CITY OF COLORADO SPRINGS EROSION CONTROL PLAN REVIEW
 This grading plan is filed in accordance with section 7.7.1503 (enacted as ord. 82-56) of the code of the City of Colorado Springs, 2001, as amended. Erosion control is reviewed in accordance with the Drainage Criteria Manual, Vol. I (2014) and Vol. II (2014); latest revisions.

TITLE PAGE
EROSION AND STORMWATER QUALITY CONTROL PLAN

Clear Springs Ranch
Access Road Fire Break

Markup Summary

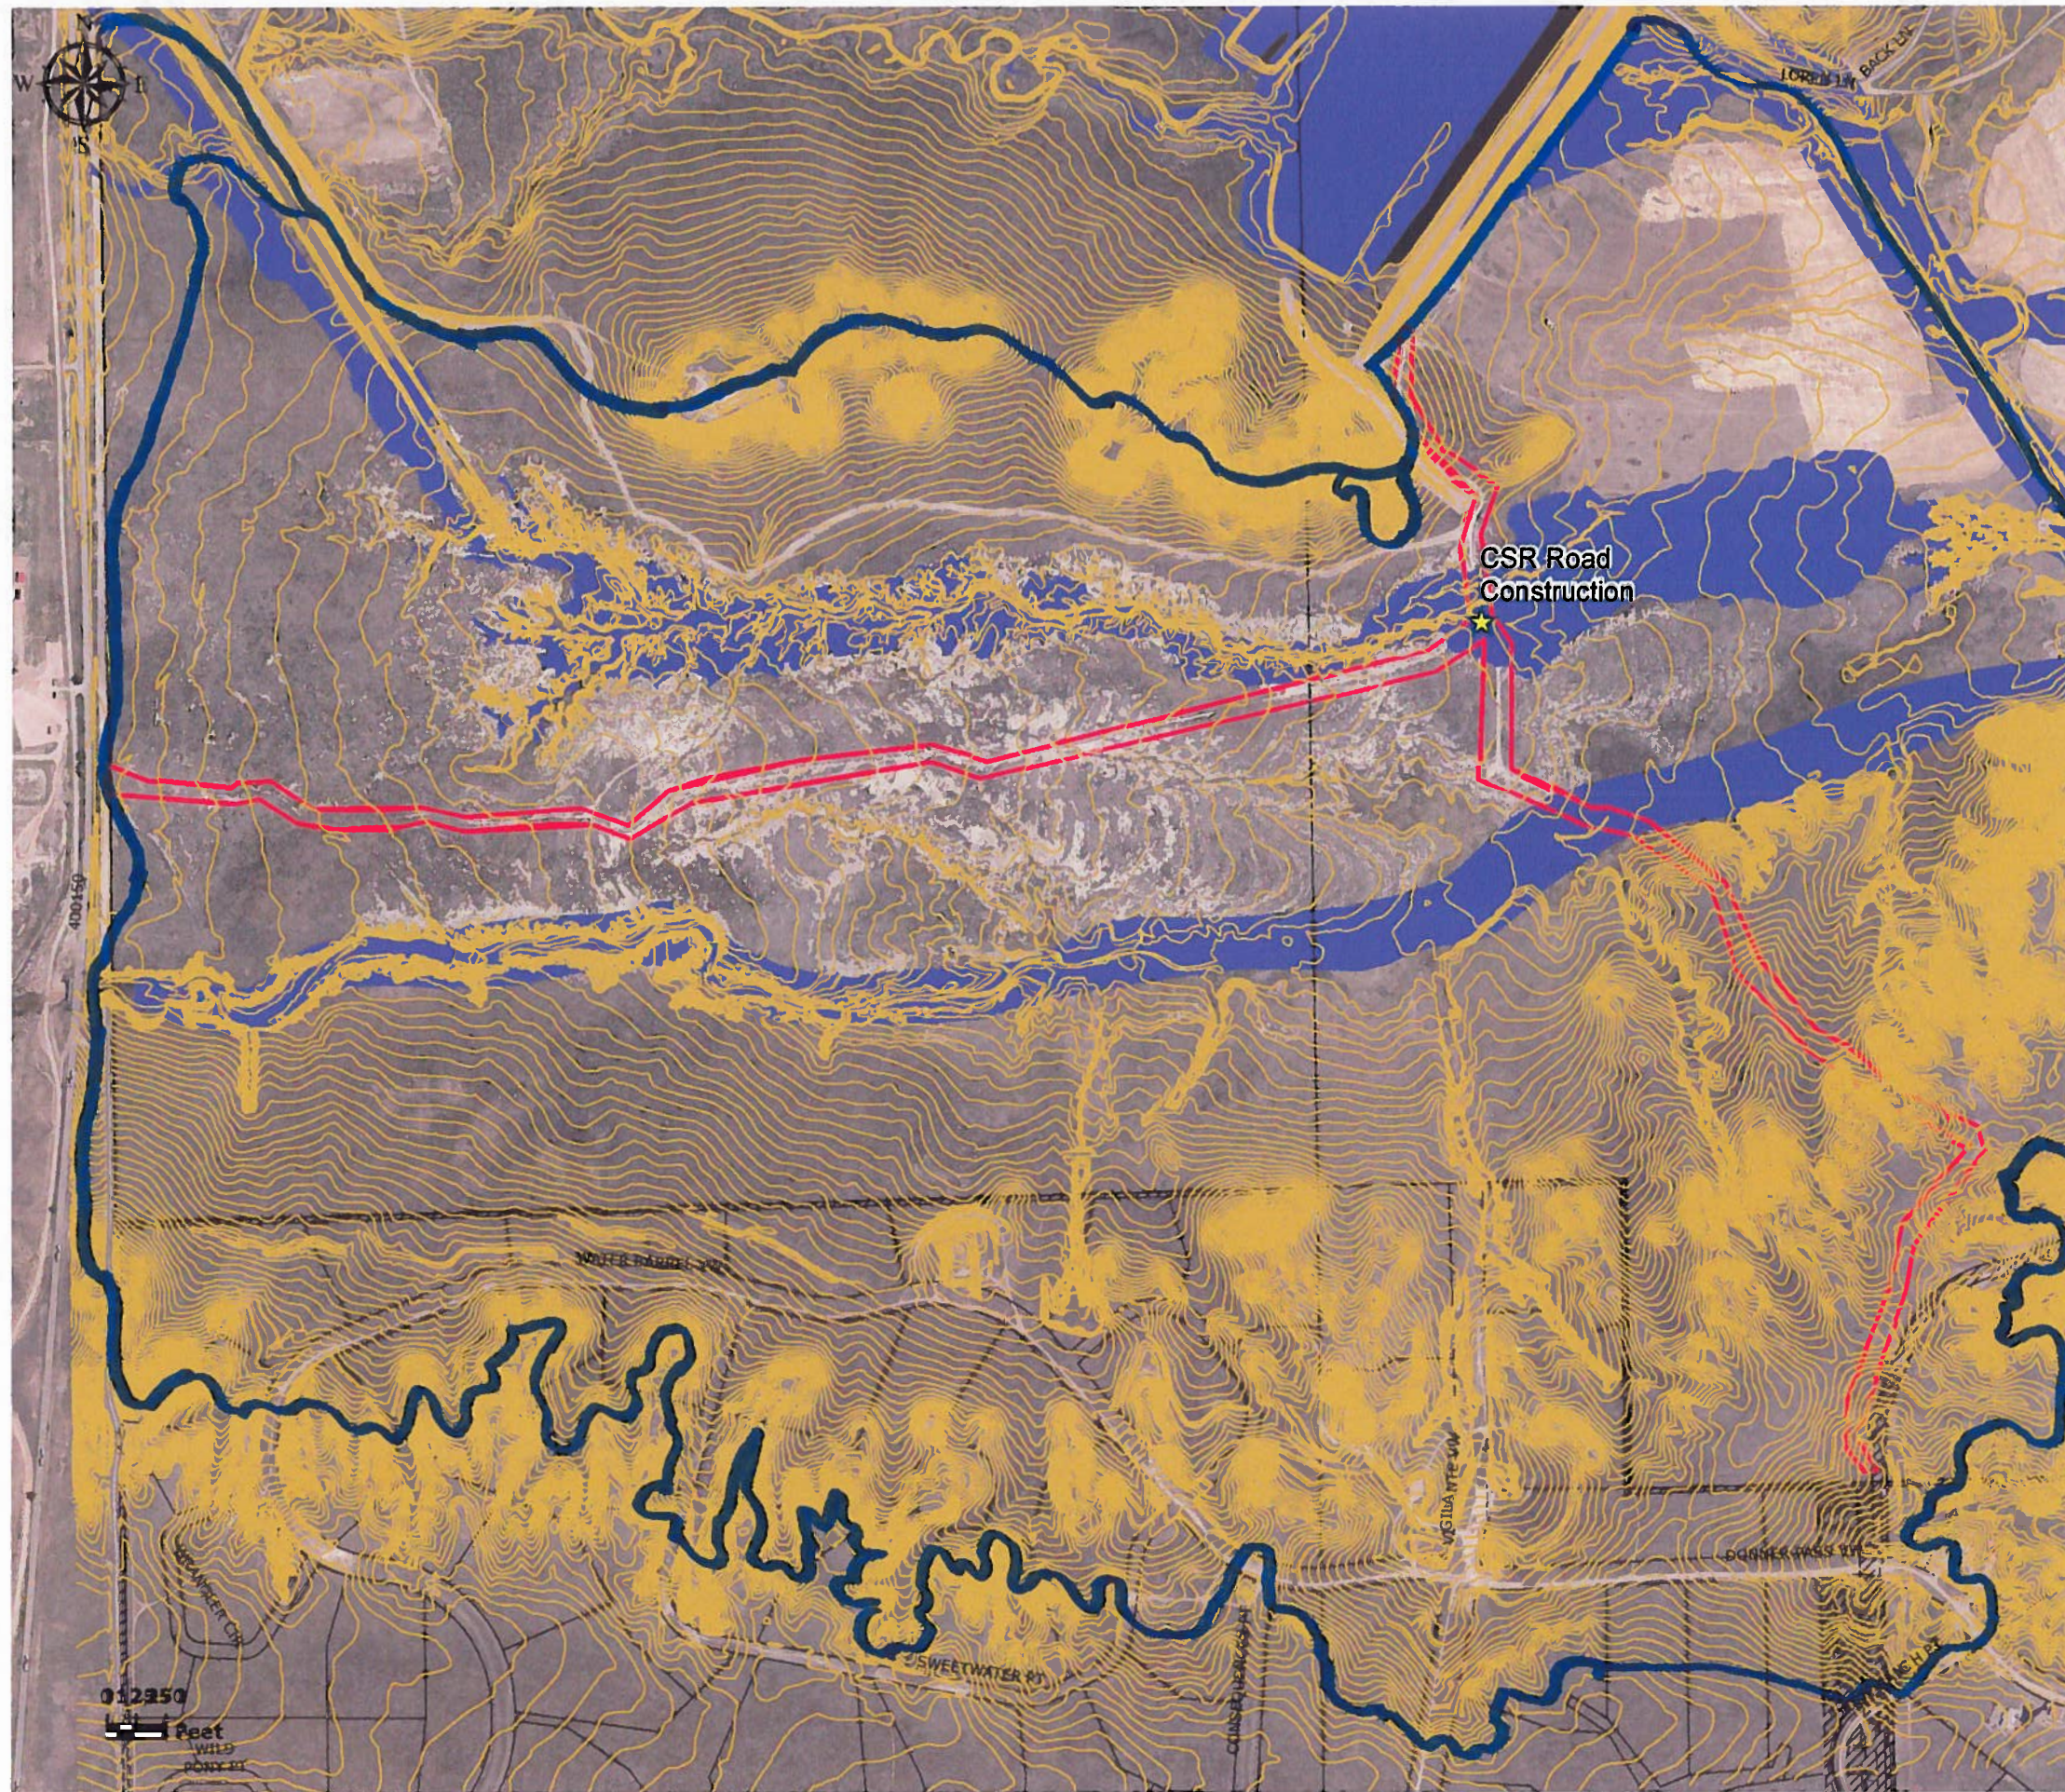
Show the location of the VTC

How many stock piles do you anticipate?
Please show or state "stockpiles to be placed on uphill side of road as needed"

Not enough information is shown to determine location of the proposed BMPs.
Define what slope would require the check dam. For clarification (can show on grading plan) please show the slopes so contractor can determine location of check dams.
